RF WINDOW SILL DETAIL M1
1-1/2"=1'-0"

MAINE MEDICAL CENTER
BRAMHALL CAMPUS
MRI #1 REPLACEMENT
PORTLAND, MAINE
ELEVATIONS, SECTIONS, AND
DETAILS

PROJECT MANAGER: DJV	PROJECT NO: 16004
AVE OF RECORD: DJV	
JOB CAPTAIN: MDR	
DRAWN BY: MDR	
SMRT FILE: AE103-16004	SHEET No. AE103

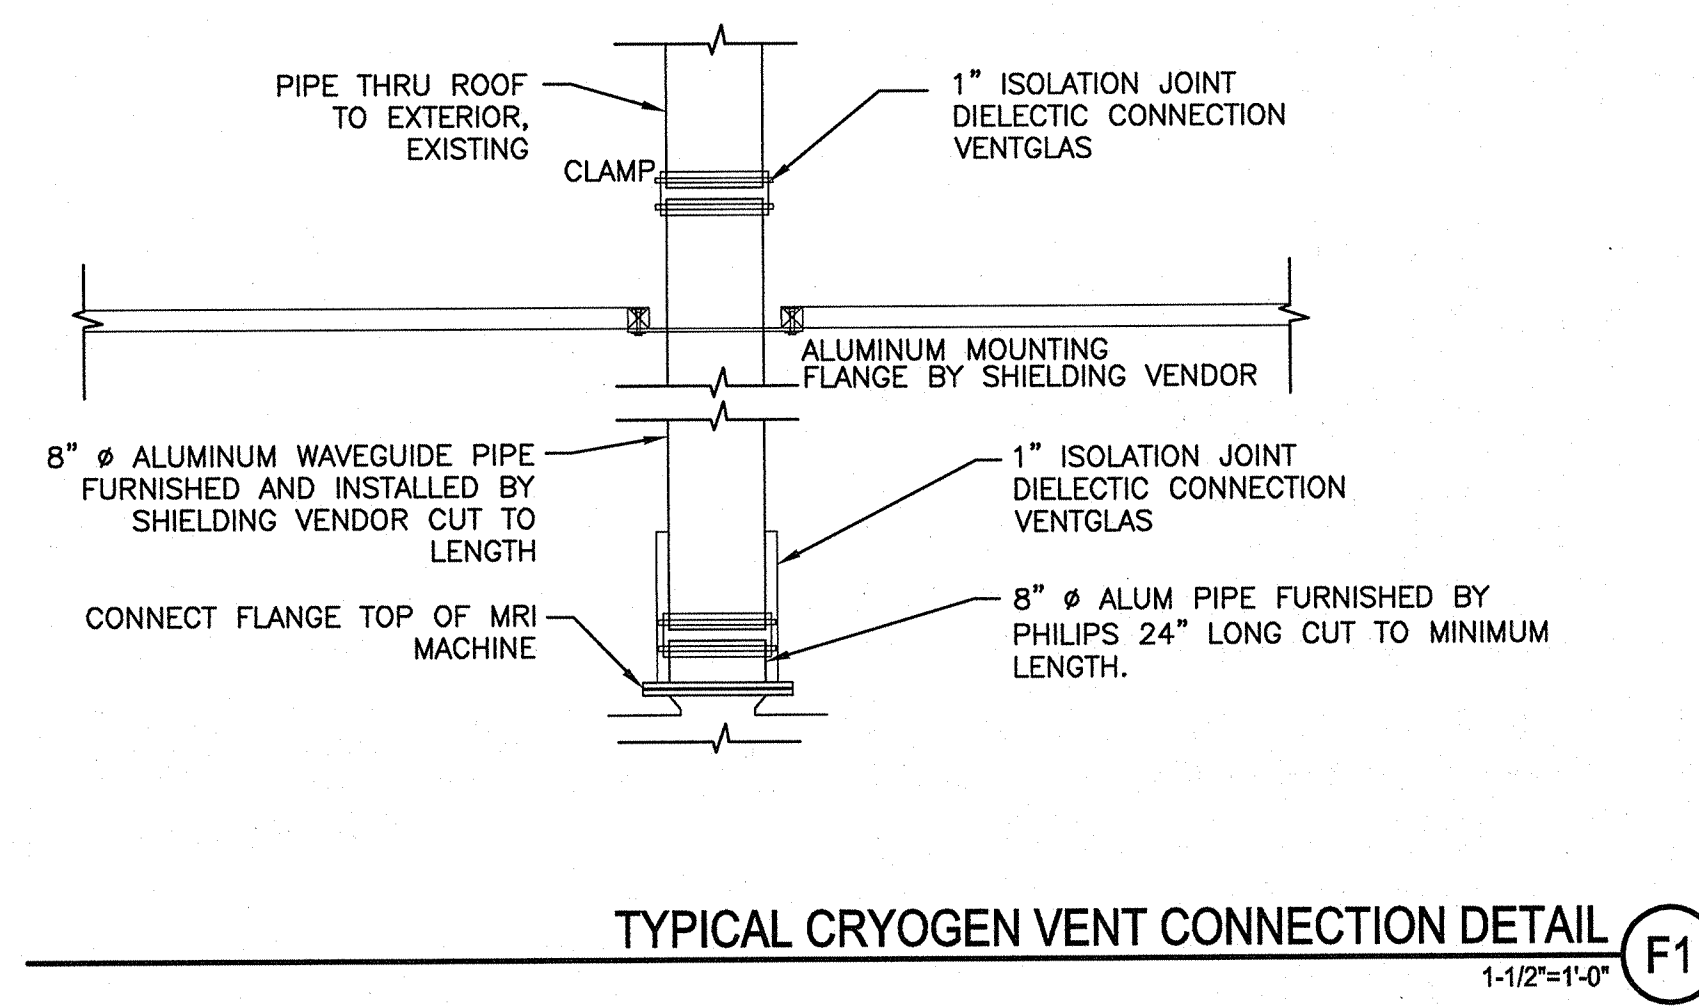
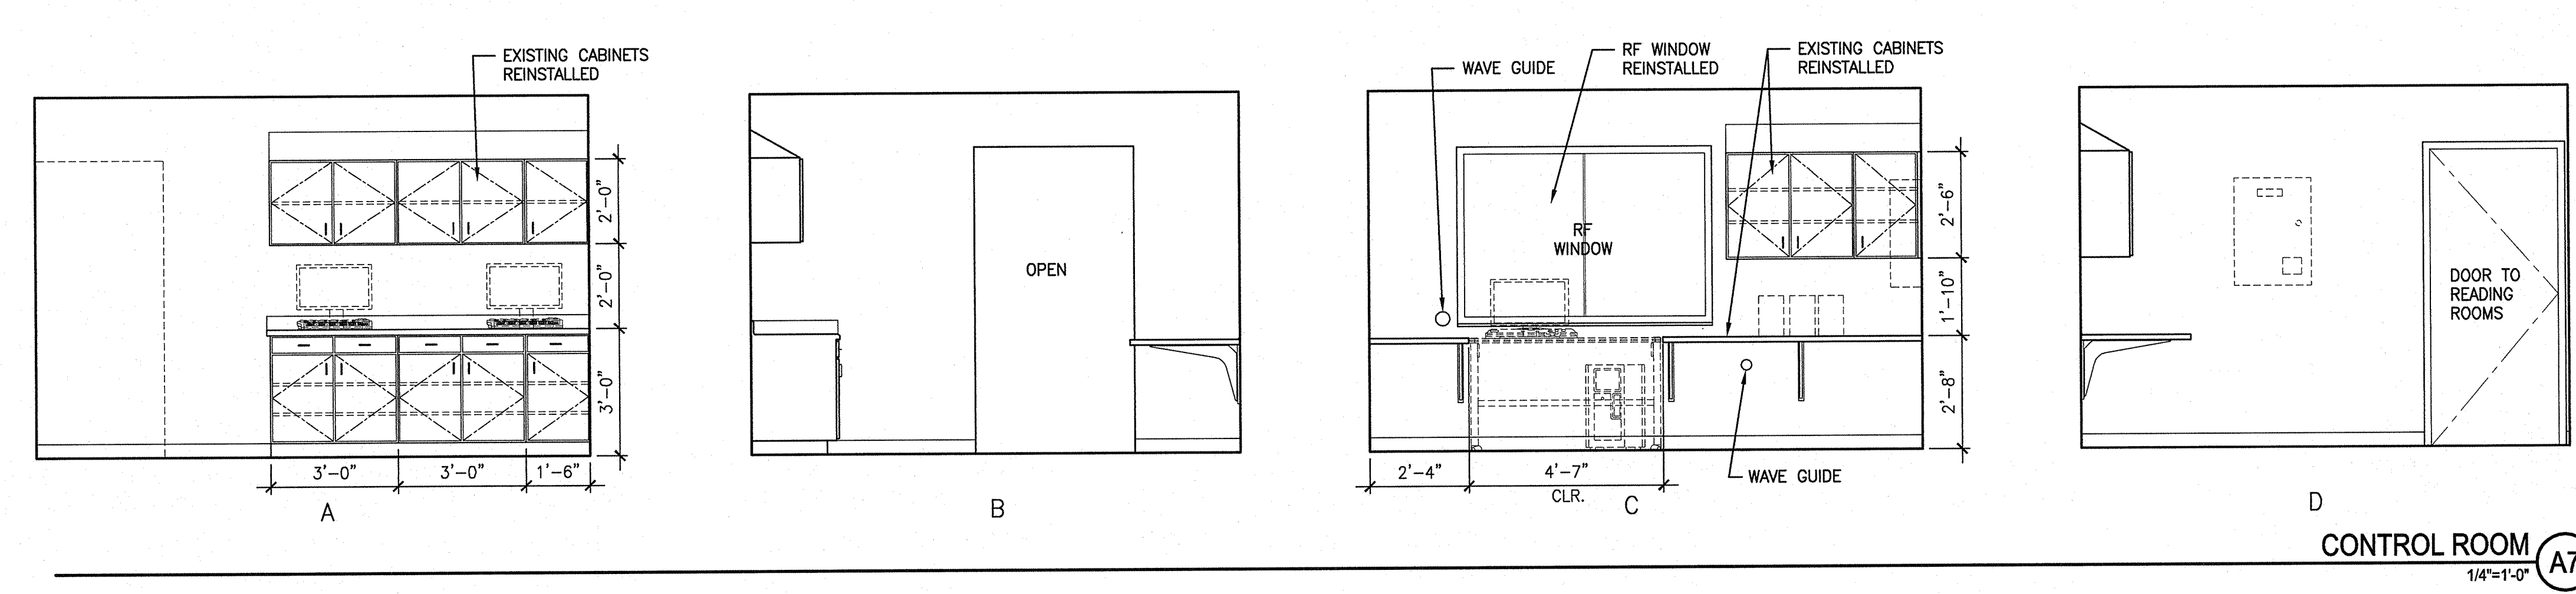
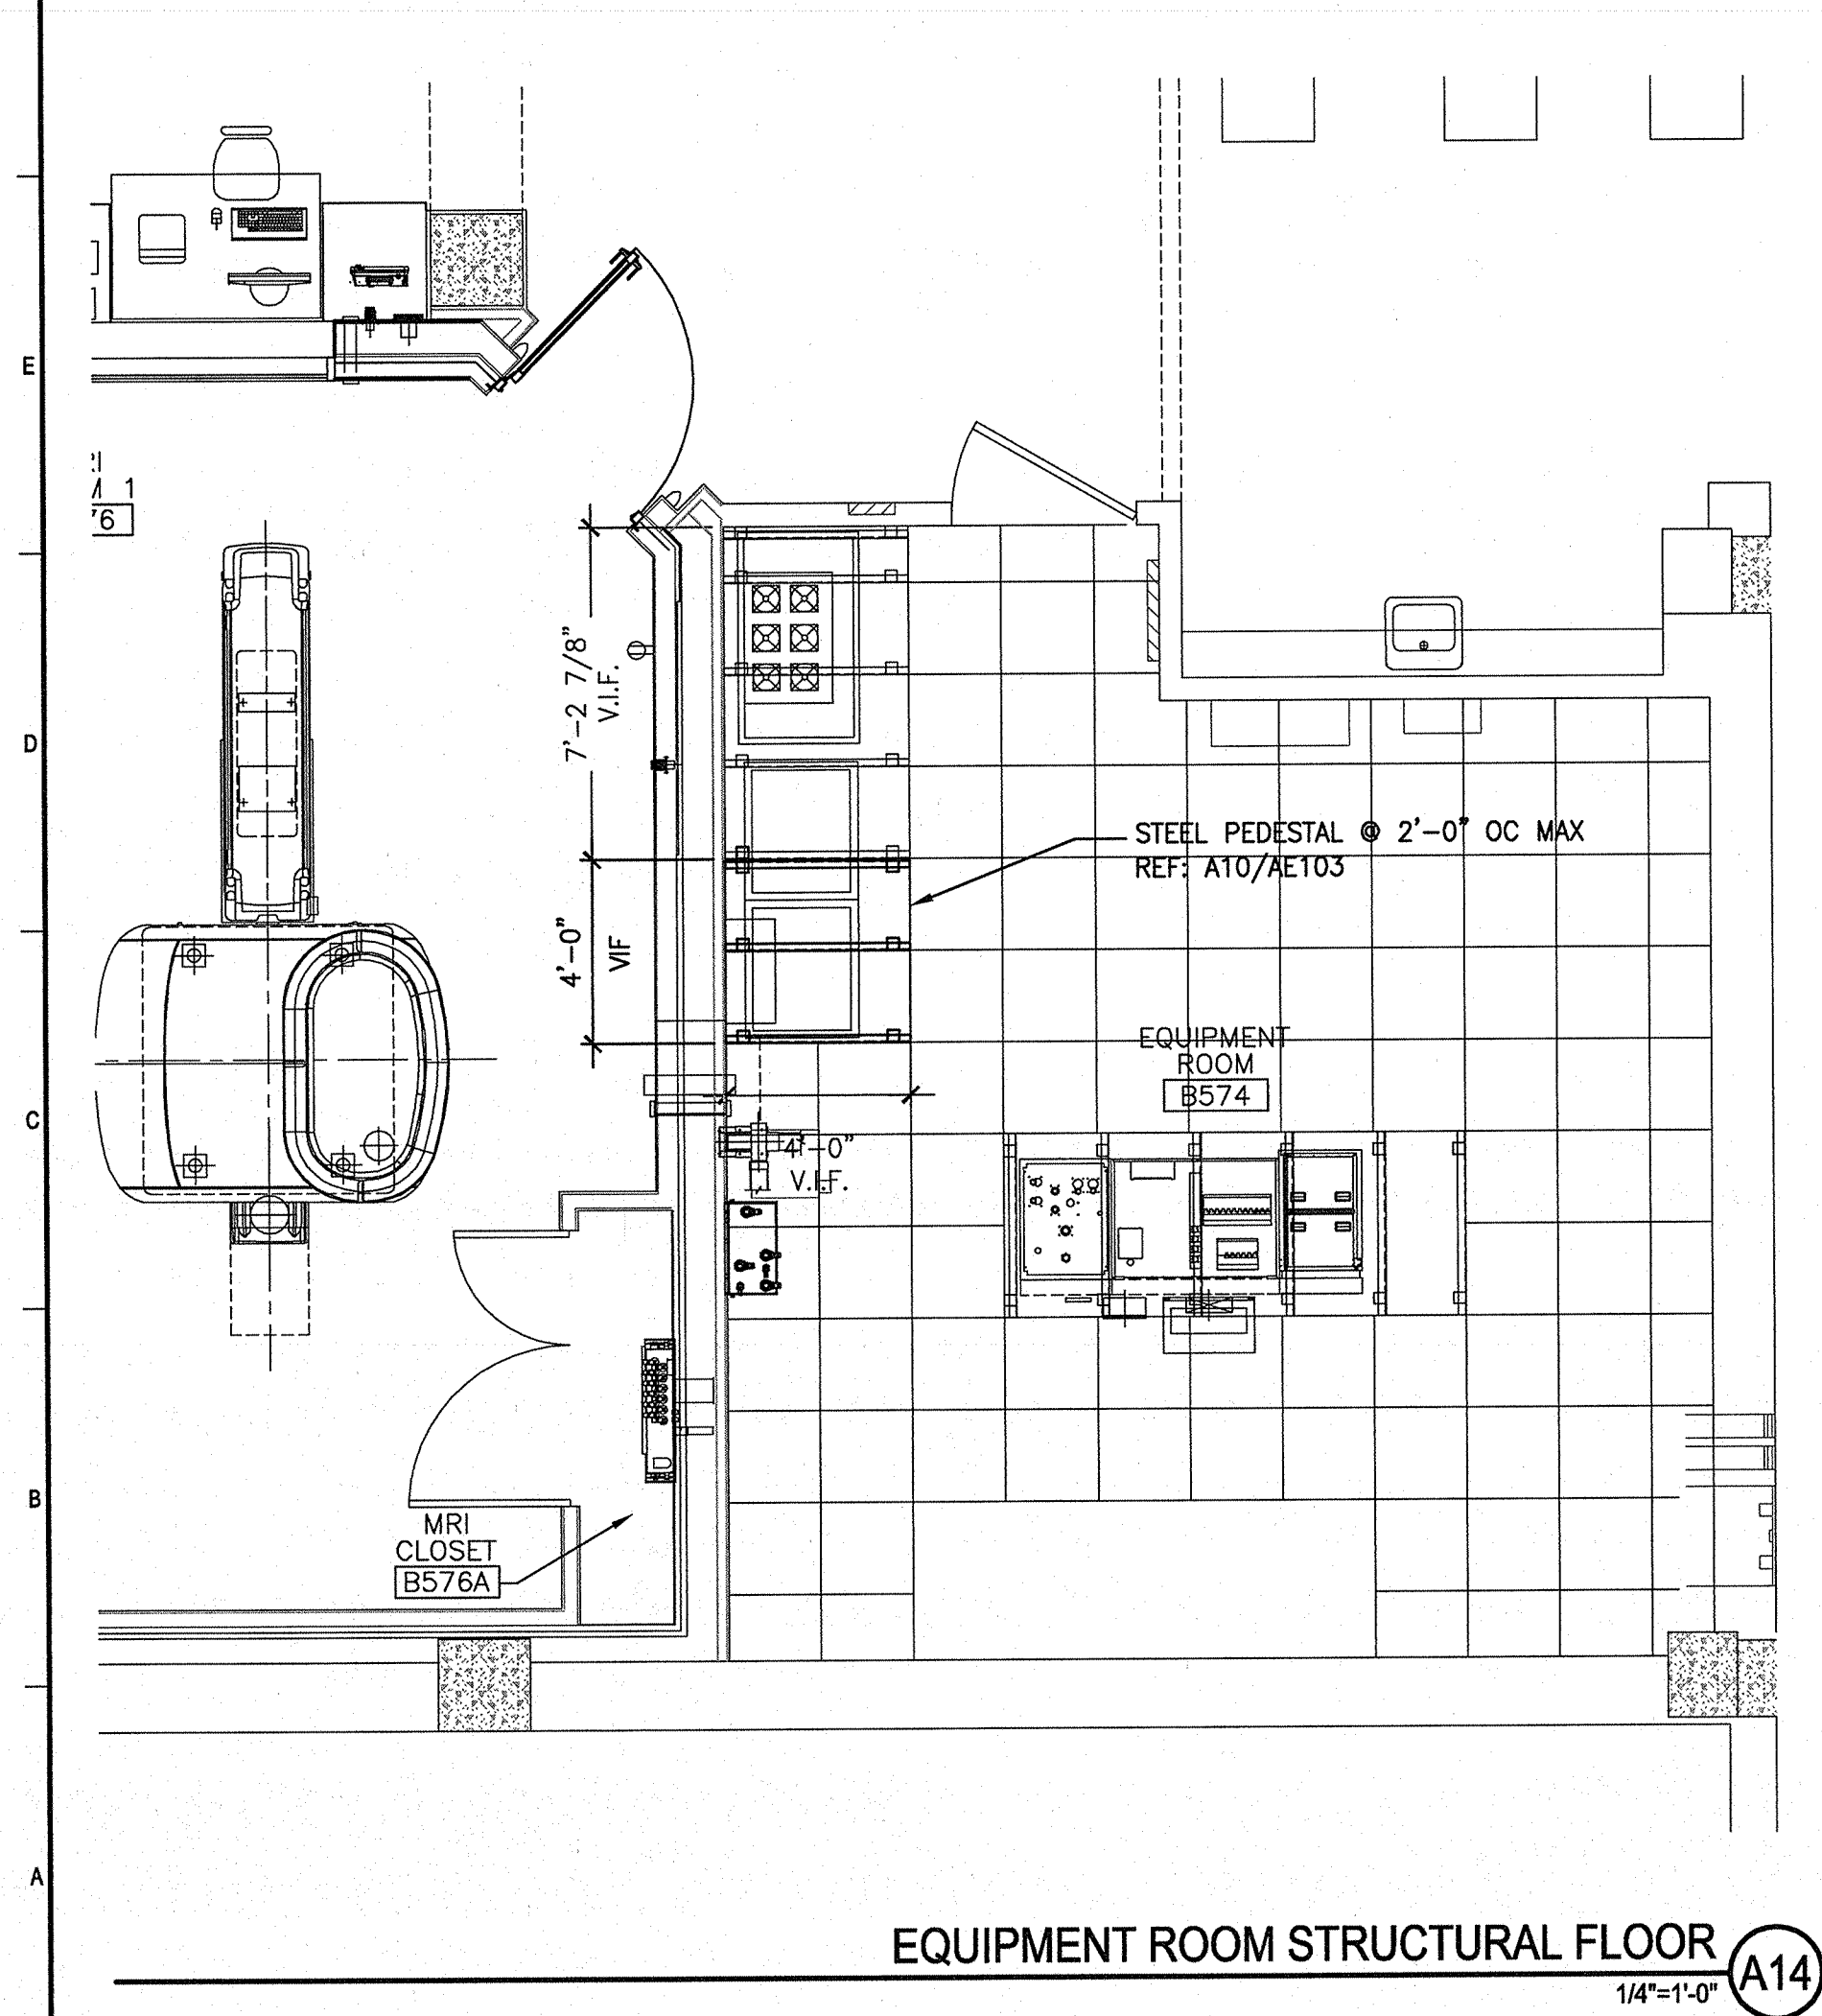
Does the new machine weigh more or less than the old?

This is magnet #2 penetration panel, not in scope of project

This is dirt below the existing slab...this is an existing condition.

Existing steel plate, once use as magnet shielding, existing condition to remain

What does this represent?

GE 3t machine (to be removed): 17,312 lbs
Philips 1.5t (to be installed): 9921 lbs
